My Ref: 2020/1450  
Your Ref:  
Date: Monday 11<sup>th</sup> December 2023  
Enquiries to: Bradley Sargeson  
Direct Dial: 01226 772142  
E-Mail: [bradleysargeson@barnsley.gov.uk](mailto:bradleysargeson@barnsley.gov.uk)

**Description:** Details of conditions 4 (boundary treatments), 8 (landscaping), 9 (EVC's) and 10 (Trees) of planning permission 2020/0946 - Change of use of A4 public house to wardrobe showroom and workshop at ground floor (sui-generis) along with erection of a single storey 100 sq. m ground floor extension to the rear and change of use of first floor to 1 No. C3 residential flat – at Hope Inn, Rotherham Road, Cundy Cross, Barnsley, S71 5QZ.

Drawing: Proposed Site Plan 2 Dwg No: 009

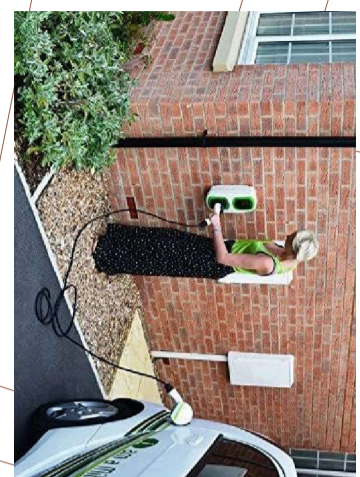
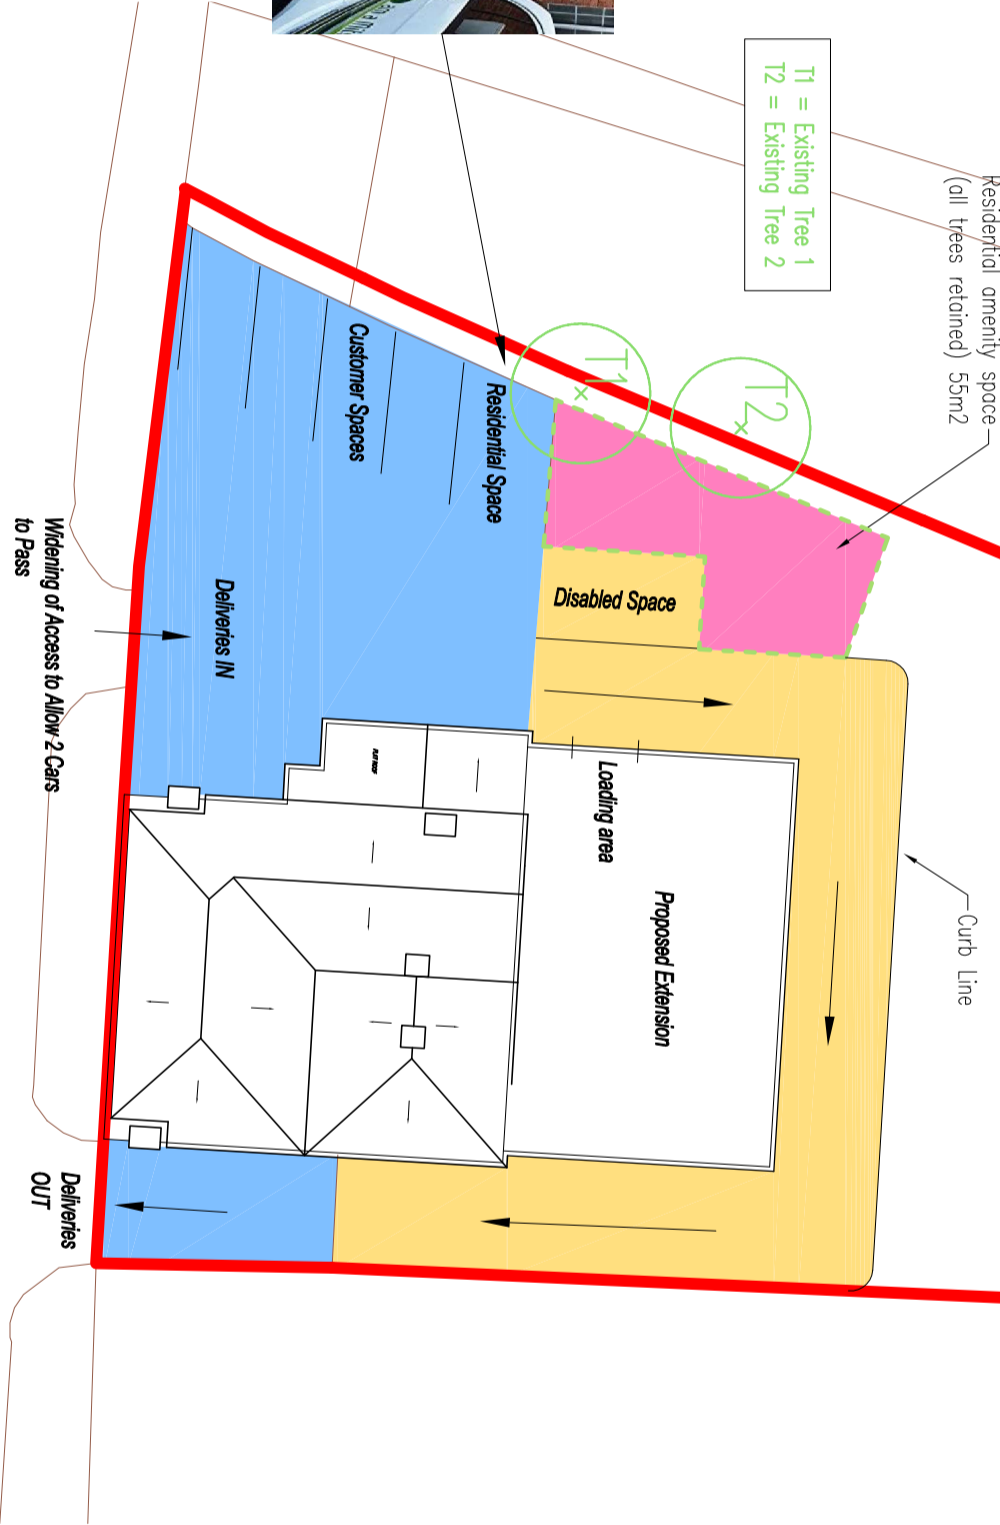
**Condition 9:** The electric vehicle charging point (EVCP) details provided within Proposed Site Plan 2 Dwg No: 009 Rev. A are considered acceptable to discharge the initial element of the condition; the condition requires the development to be carried out in accordance with the approved plans, and in accordance with the procedures set out in the above document.

Project : The Hope Inn, 29 Rotherham Road, Barnsley, S71 5QZ		Dwg No: 009
Drawing: Proposed Site Plan 2		
Date: 4.12.20	Scale : 1:200 A1	Rev: 0

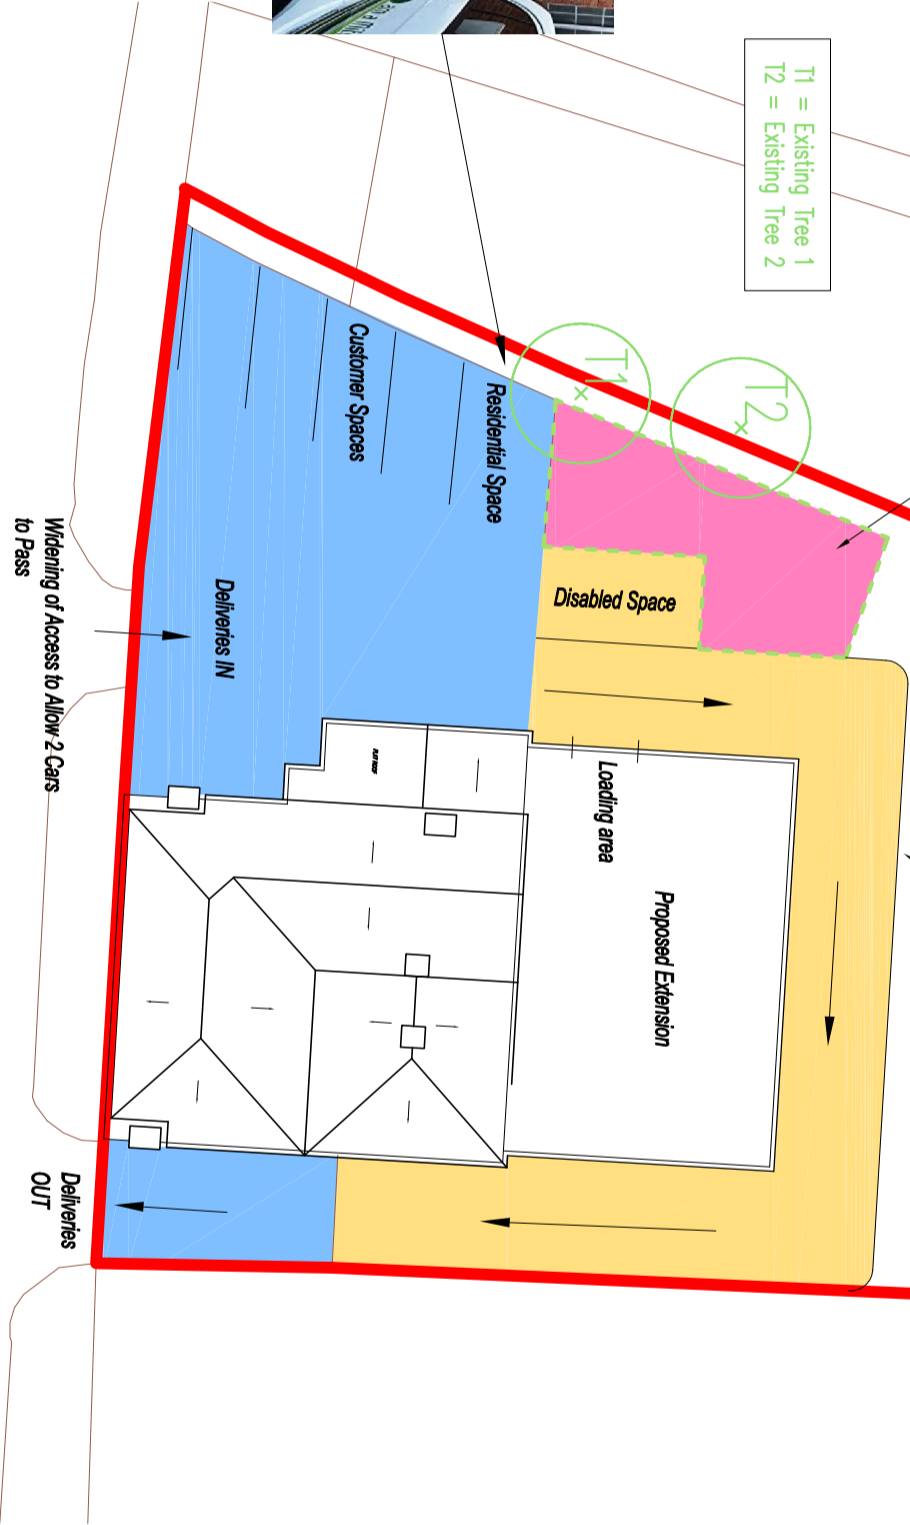
**Condition 8:** As per the letter dated 09 February 2021 from Richard Gilbert, the initial elements of the condition were partially discharged. Richard's response stated that the details of the Proposed Site Plan 2 Dwg No: 009 Rev. 0 were satisfactory in respect of amenity space and turning area. However, the plan remained silent on the area within the red line boundary to the north of the site. The LPA is aware that this area has been subject to burning of materials and is generally unkempt prior to occupation of the Hope Inn. The area is also visible through the palisade fence and the purpose of the condition was to understand how this area is to be managed aesthetically. Given the business operation on site it was understood some storage of materials may take place and it will be necessary to provide these details on an amended site plan. It is acknowledged that a revised plan was submitted referenced Proposed Site Plan 2 Dwg No: 009 Rev. A. The revised plan does go some way to addressing the aforementioned points. However, the information provided is still lacking in detail, specifically, with respect of the proposed soft landscaping to the north of the site within the red line boundary. The condition, therefore, is **NOT** fully discharged and remains outstanding until such details are supplied.
